**Consultation Response from KC,
Highways Development Management**

2022/93938 Piazza Shopping Centre, New Street and Albion Street, Huddersfield, HD1 2TR

Change of use from A1 (business retail and storage) to C3 (residential) 34 studio flats at first and second floors and external alterations

Date Responded:13/02/23

Proposed Second Floor Plan

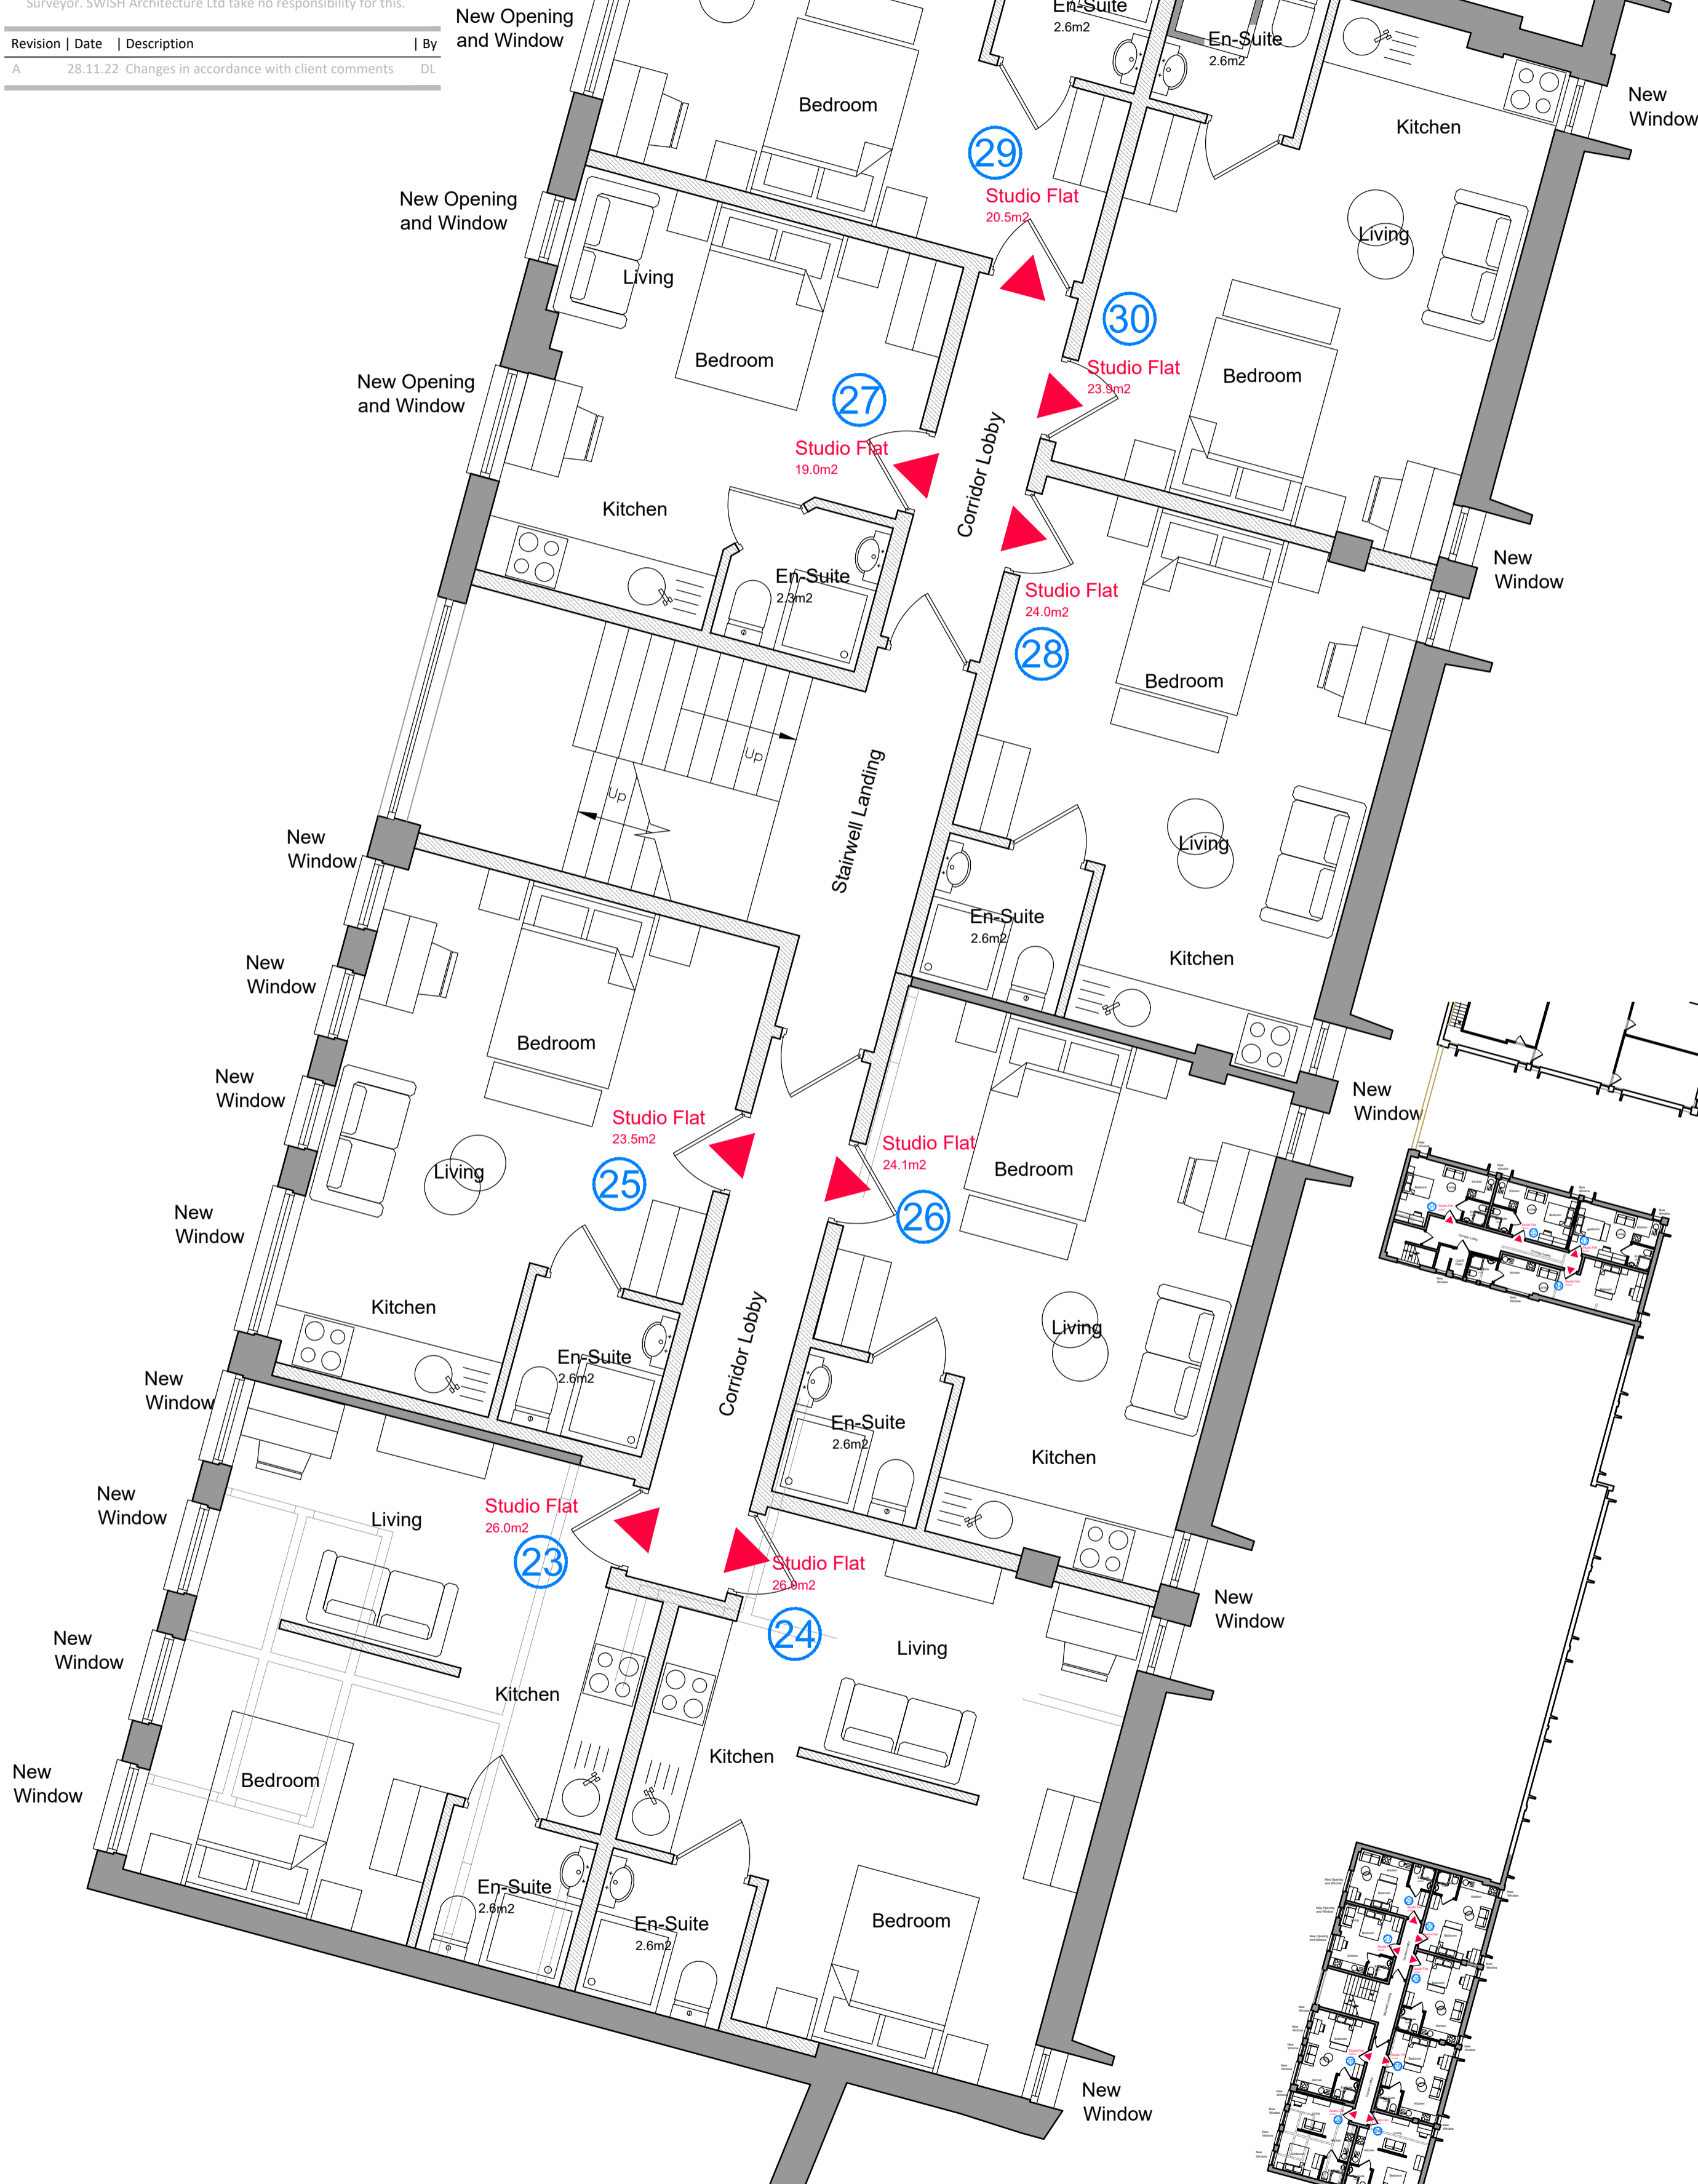
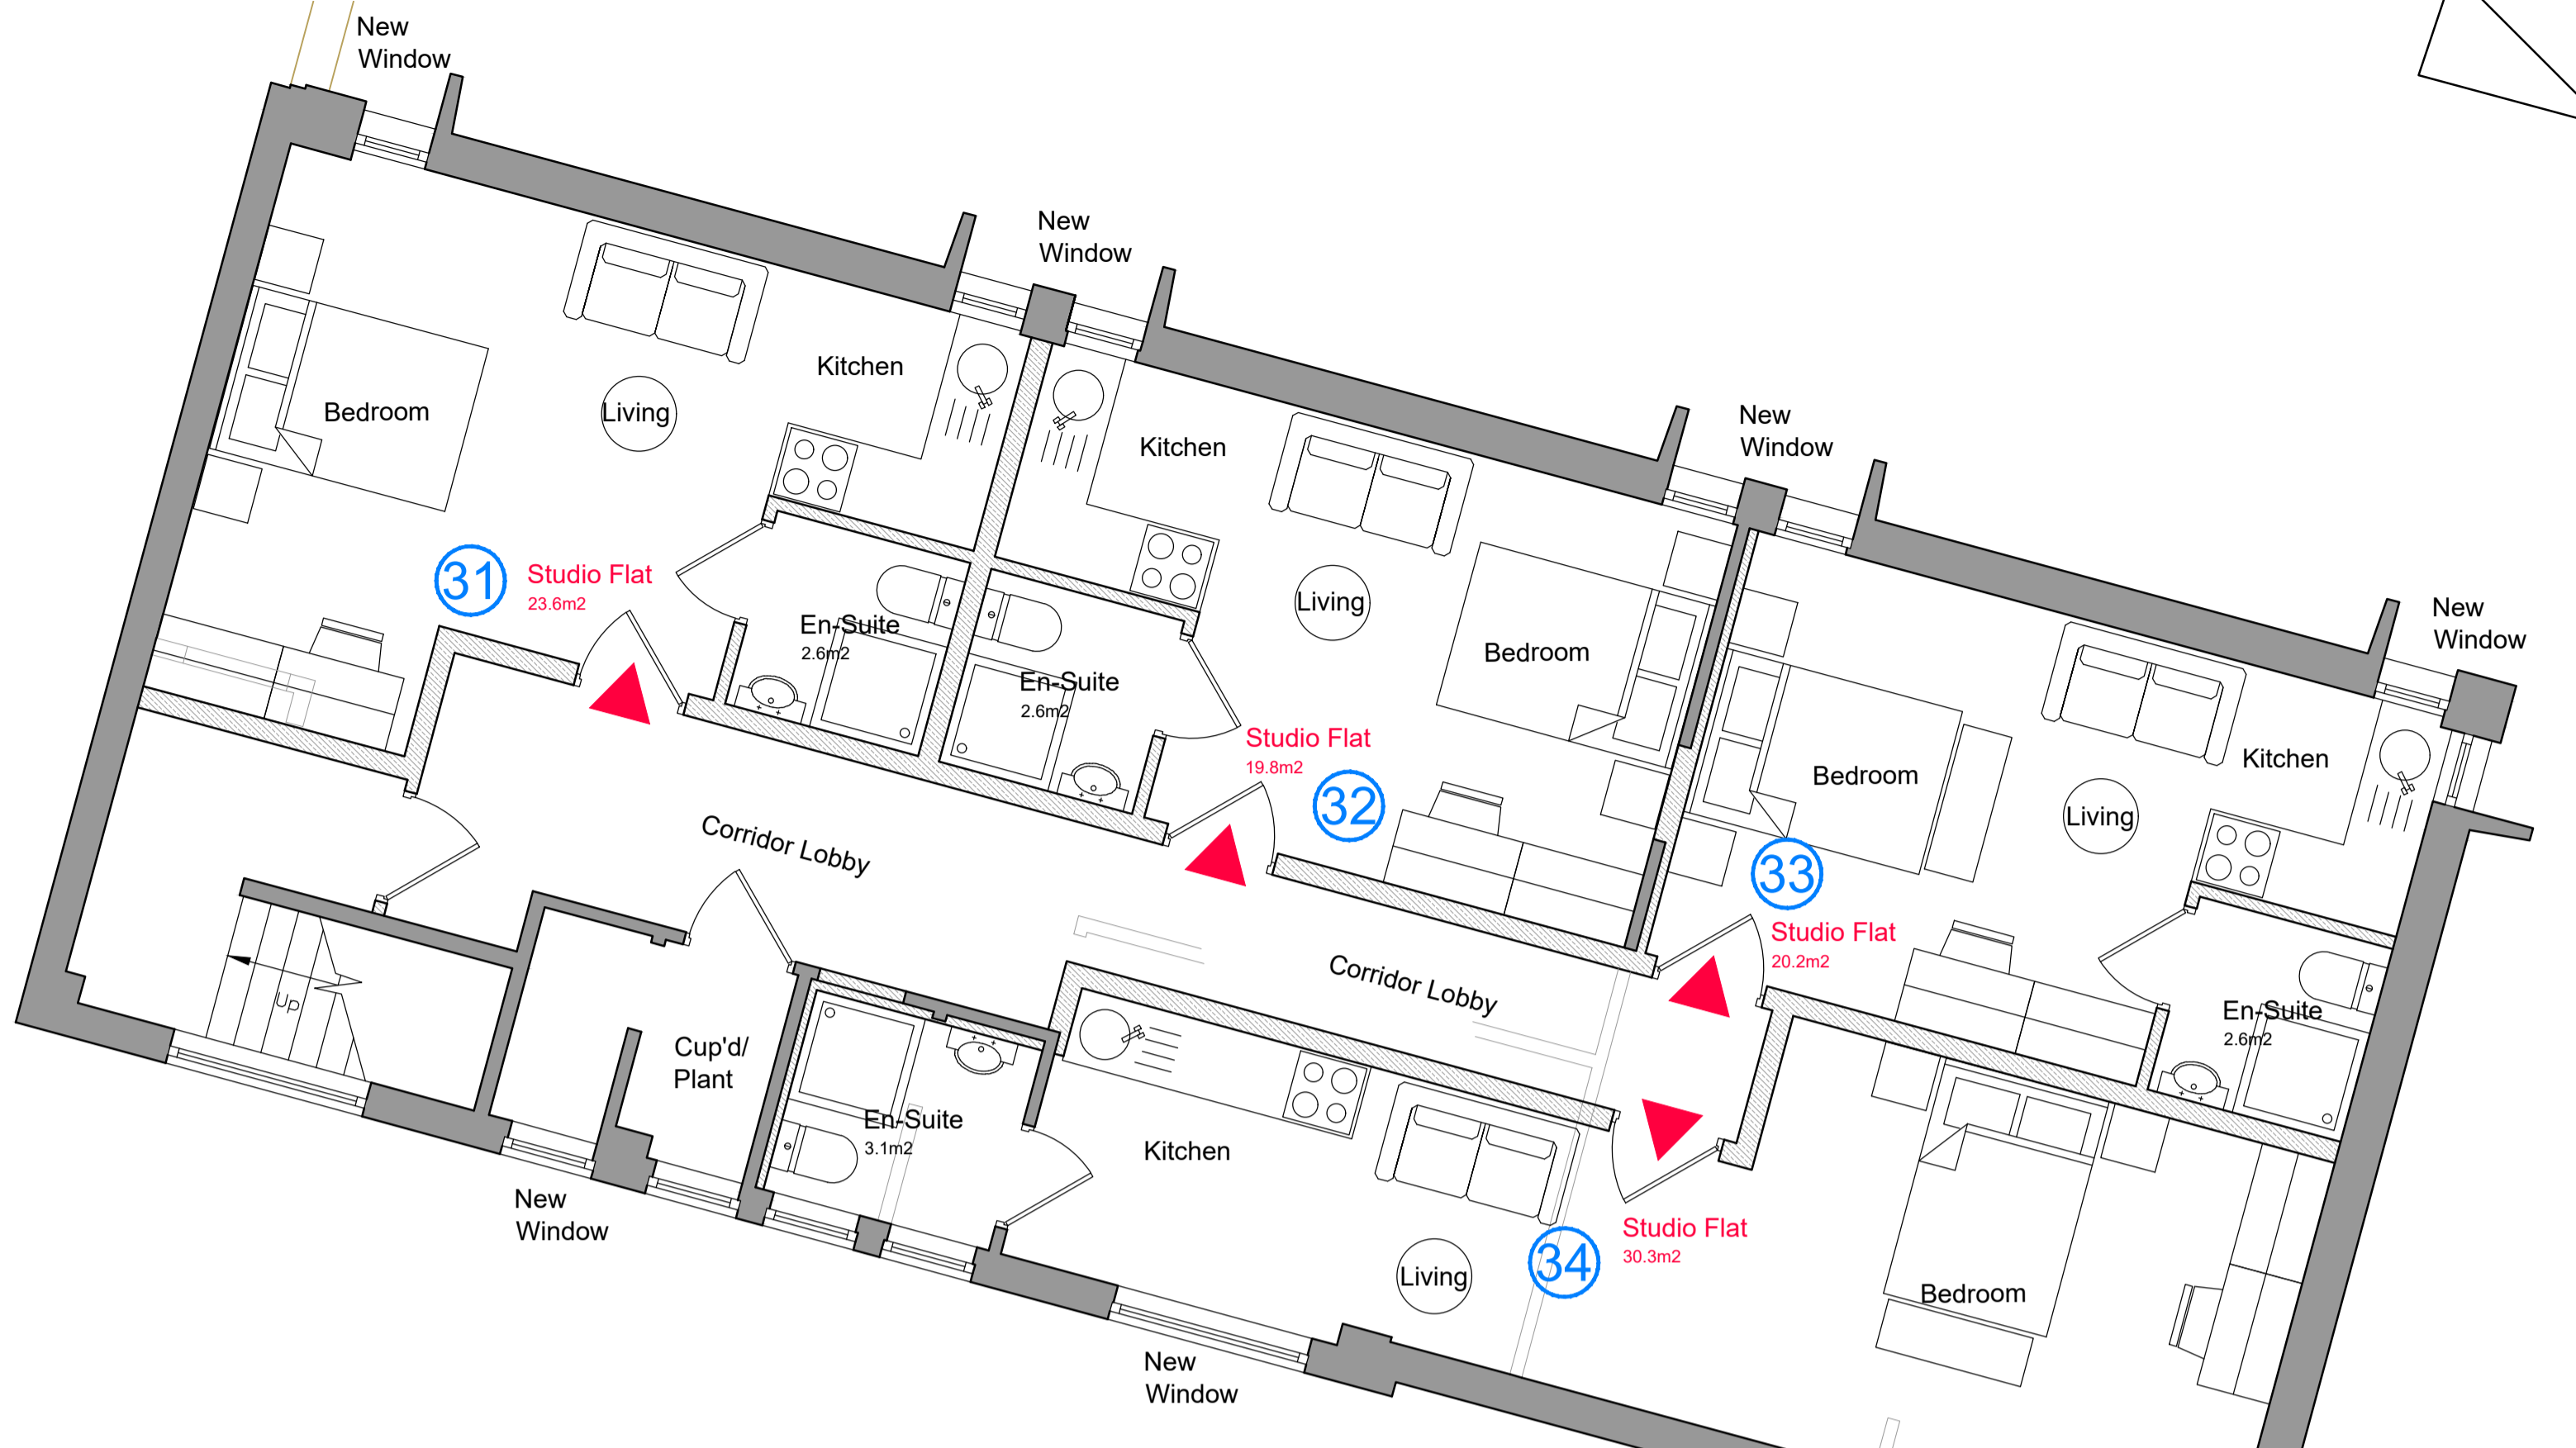
No details were provided relating to waste storage and collection beyond the mention that "ample refuse storage is also provided for the proposal, with space allocated close to the proposed development to the internal courtyard of the site" The internal courtyard is not clearly indicated on the supplied drawings and there is no indication of a route through from the proposed dwellings to any internal locations within the site. We would need to see how the waste from the proposed dwellings would be collected, including the position of a collection presentation point adjacent to a suitable adopted highway and located to follow Kirklees waste strategy guidance. This could be conditioned.

Before development commences, details of suitable storage, bin presentation points and access for collection of wastes from the dwellings hereby approved shall be submitted to and approved in writing by the Local Planning Authority. The approved details shall be provided before first occupation and shall be so retained thereafter.
